Your Ref: ACP-323171-25
Planning Ref: 2460322 - Kerry County Council
(Please quote in all related correspondence)

Re: Notification under the Planning and Development Act, 2000, as amended.

Re: Appeal Referral regarding Kerry Planning Application 2460322 for permission for the development at a 22.6ha site at Reenroe, Emlaghmore West, Ballinskelligs, County Kerry. The development will consist of an integrated tourism/leisure park first comprising of the partial demolition, extension and redevelopment of the existing derelict hotel, to include; 4 no. self-catering studio apartments; 3 no. one bed self-catering apartment; 15 no. two beds self-catering apartments; a bar; dining room; rooftop restaurant; shop; ESB substation and switch rooms; standby generator room, and bin stores. The remainder of the proposed development will include the following: 6 no. hobbit huts, 21 no. glamping pods, 25 no. holiday homes, 144 no. mobile homes, 20 no. campervan stands, 0.8ha tent camping area, washroom and toilet facilities 58m², maintenance building 618m², leisure complex (with a swimming pool) 1,339.5m², surf shop 191.7m²/café 126.5m², natural play area, central park area, 151 no. car parking s

Figure 2-22: Roads and footpaths where no lighting will be provided.

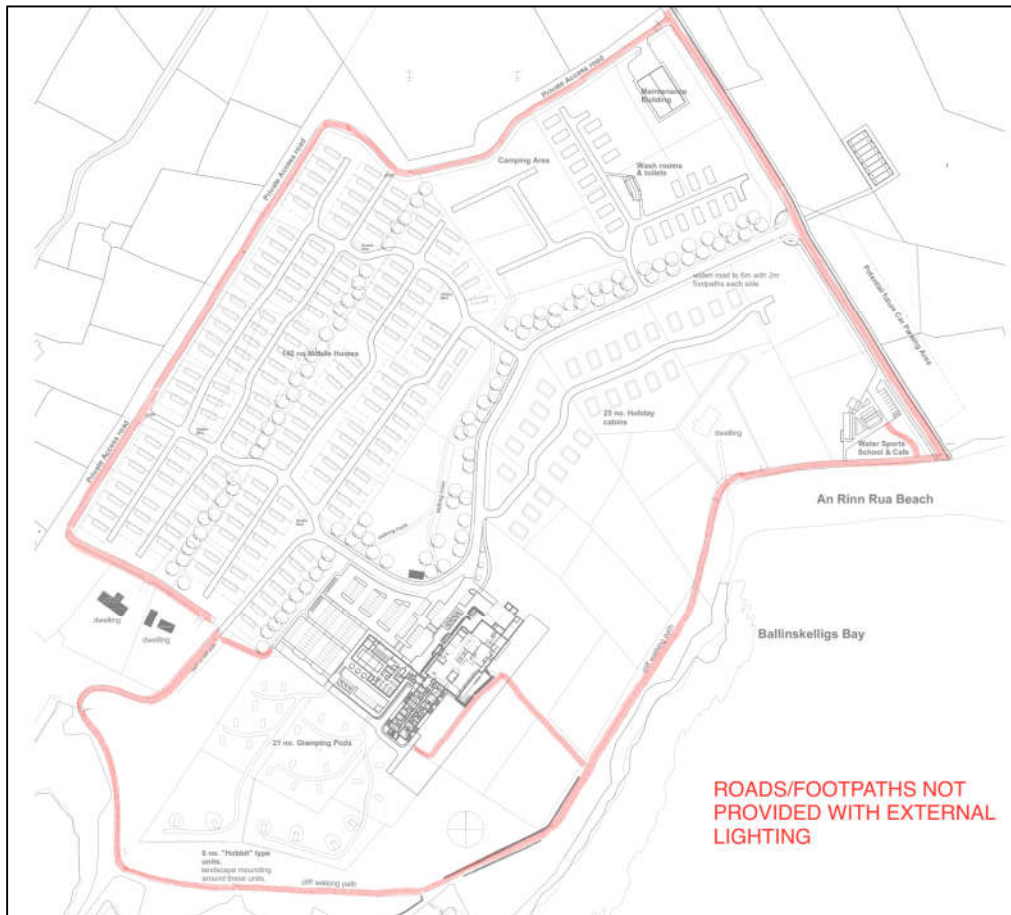
The impacts of lighting on Manx shearwater and Storm Petrel have been examined in the Natura Impact Statement (NIS), and mitigation has been proposed, in Section 6.3 of the NIS. However, this mitigation is very generic and is not tailored to the site. The Lighting Layout submitted with the Planning Application does not appear to have the recommendations put forward in Section 6.3 of the NIS incorporated into it; for example, the Lighting Layout includes bollard lighting, the use of which is discouraged as per the recommendations of the NIS.

Prior to commencement of the project, the lighting design and available lighting units shall be reviewed in consultation with a qualified Ornithologist, taking into account best practice mitigation, in order to refine the design to accommodate the least light spillage to Ballinskelligs Bay. During construction, and at the commencement of operation, the lighting

and, in the latter case, light spillage to sea, shall be assessed by the Ornithologist, and a report sent to the Planning Authority and to the National Parks and Wildlife Service
